Application No: WA/93/20/PL
Site Address: Land East of Tye Lane Walberton BN18 0LU
Description of works: Alternative vehicular access off Tye Lane & emergency access off Avisford Park Road, along with minor highway works following WA/95/18/RES. This site is in CIL Zone 2 (Zero Rated) as other development.

Thank you for your internet representation made on 29th April 2021 which has been recorded as an objection with the comments as follows:

AVISFORD PARK ROAD

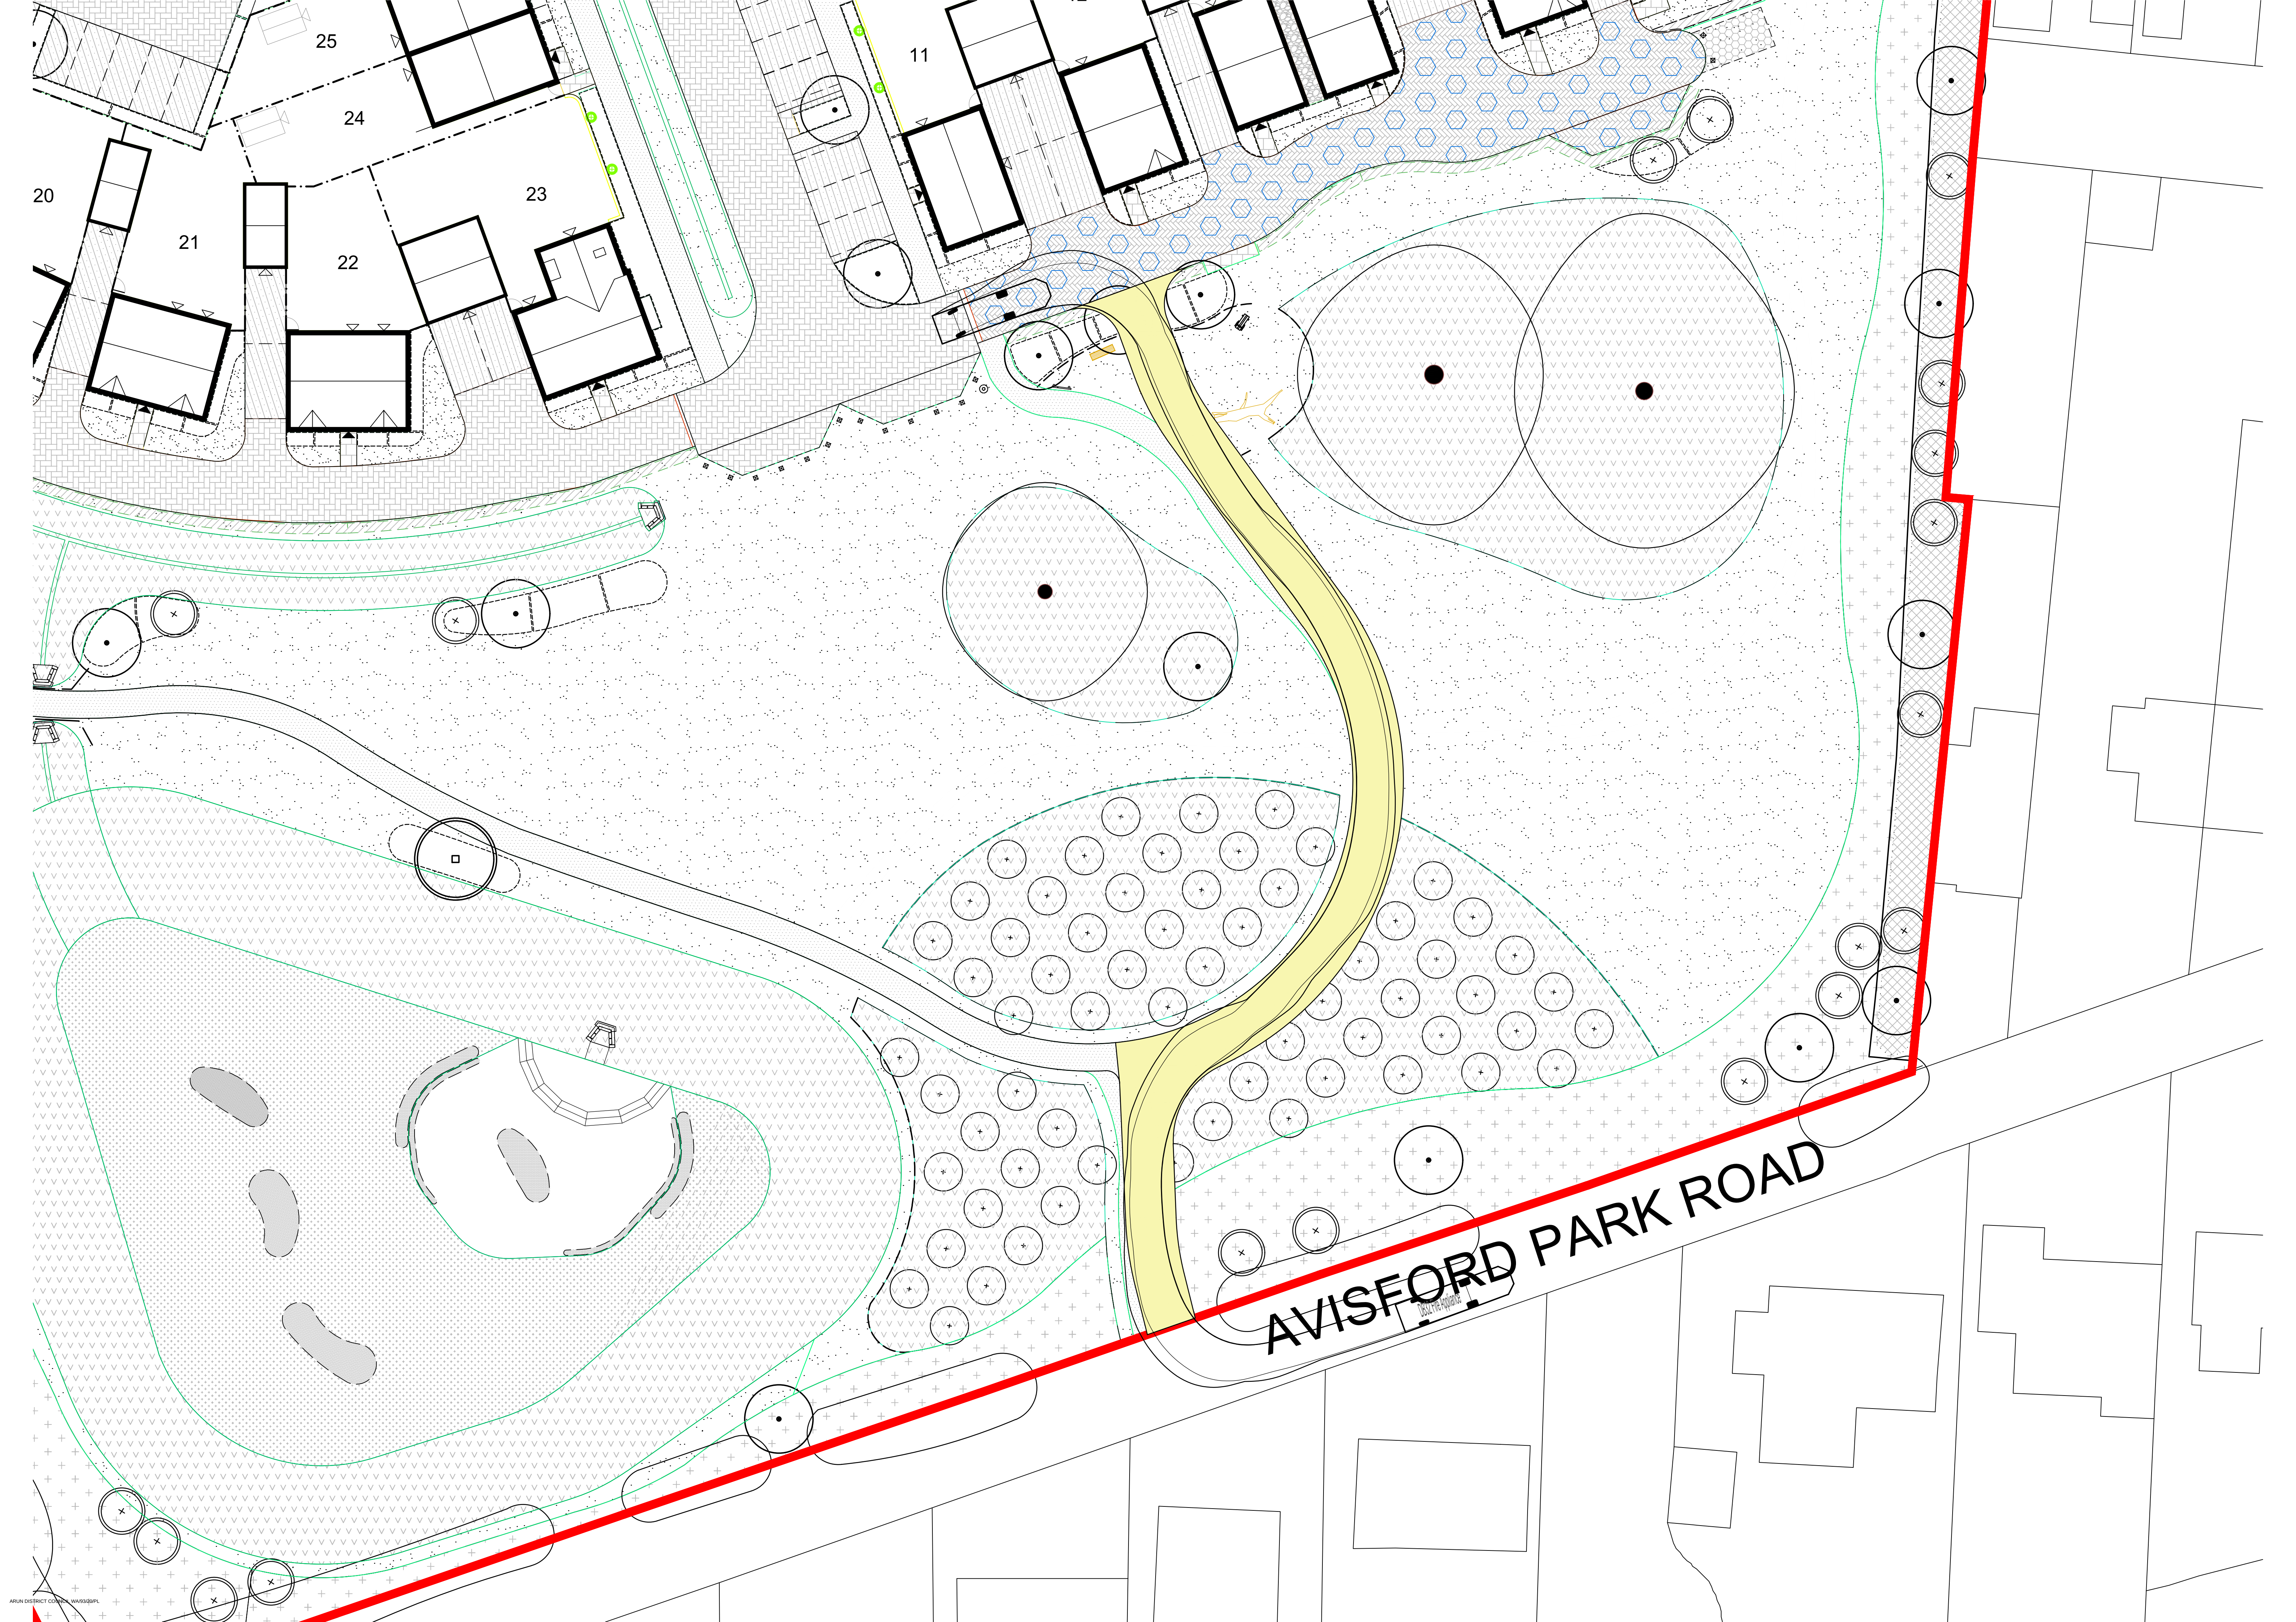
I object to an emergency access being added to avisford Park Road for the following reasons:

It is NOT safe!

Avisford Park road is an unadopted road that is maintained by the residents so the cost of its upkeep will be greatly increased due to the additional vehicles.

The footpath that has currently been granted permission is located in a very dangerous position and myself and my neighbours will find it very difficult to pull away from our drives safely with the risk that someone will walk/cycle out from the footpath.

The road itself has a 10mile an hour limit and there are many children that live and play on the road. This won't be possible if there is a risk that an emergency vehicle will come speeding along it exceeding the speed limit.

If the footpath is having a bollard in the middle of it, will this not impact the amount of time that it takes for the emergency services to reach their destination if they have to stop the vehicle and remove the bollard. What is to stop residents of the estate taking the bollard out and using the emergency access as a road?

and finally Avisford park road is very narrow and if any of us have visitors that park outside our houses there is not going to be enough room for an emergency vehicle to get through so this defeats the object completely.

I would like it noted that I have voiced my concerns about the location of the footpath as in my opinion it is an accident waiting to happen!!
